Your Ref: OWPC19465
Our Ref: EG/43/18/PL 15-06-2018
Please ask for:
Mr S Davis

Change of use from shop (A1 Shops) to micro-pub (A4 Drinking Establishment).

42 Barnham Road Eastergate

PROPOSED GROUND FLOOR PLAN 1:100

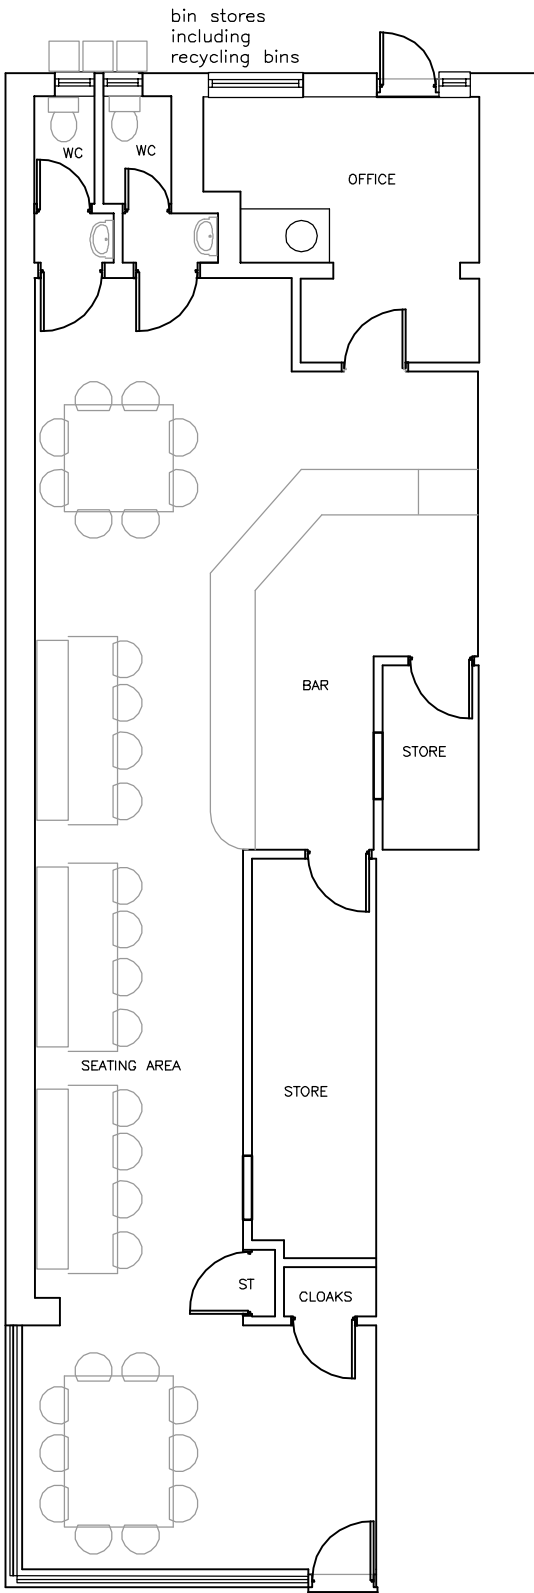
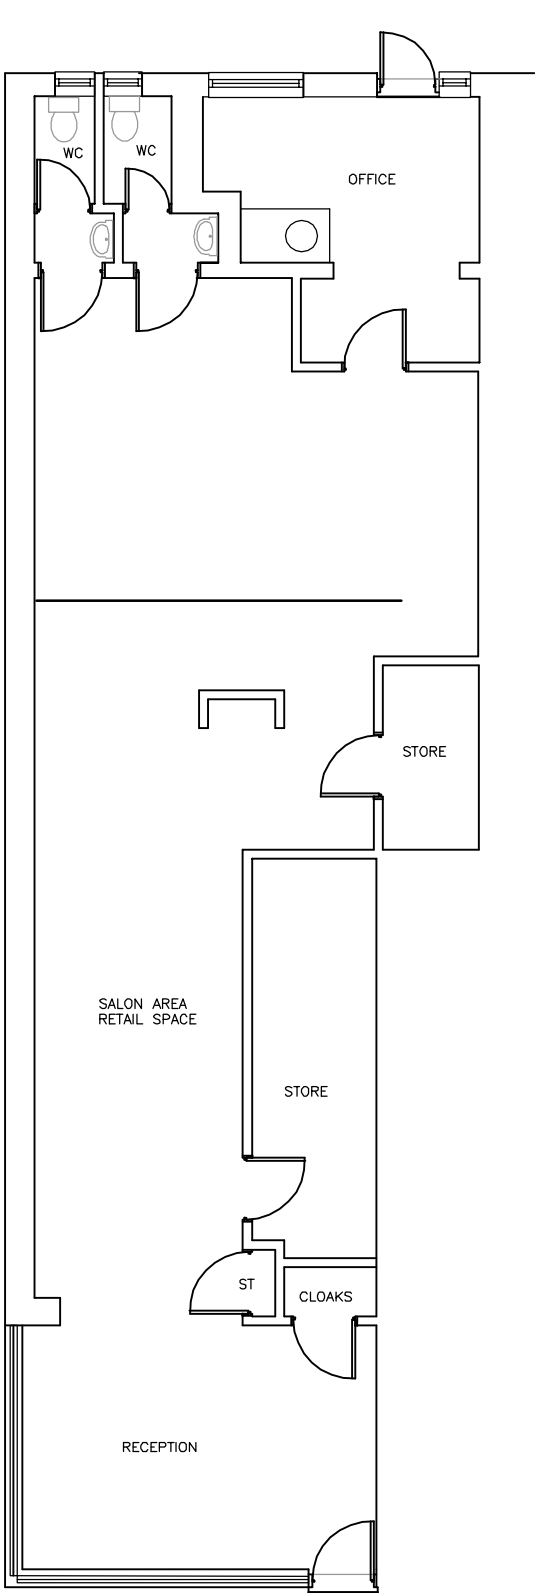
- 1. (Acoustic Assessment) required/needed for noise levels and soundproofing for existing tenants already occupying the two flats above. 30 - 50 people has the potential to create high levels of background noise.*

- 2. (Footfall), proximity to the existing tenants already occupying the two flats above and the local school.*
 - 3. (Fire Safety Regulations, Health & Safety) Concerns for in and around Emergency escape plans and risk assessment. Also, concerns regarding the proposed outside seating area for 8 people consisting of removable barriers, printed sign with poled frame will create an obstruction and a hazard to the pathway leading to and from the communal entrance/exit for the existing tenants who already occupy the two flats above. Only 2ft/24" of separation between the two doors currently exist.*
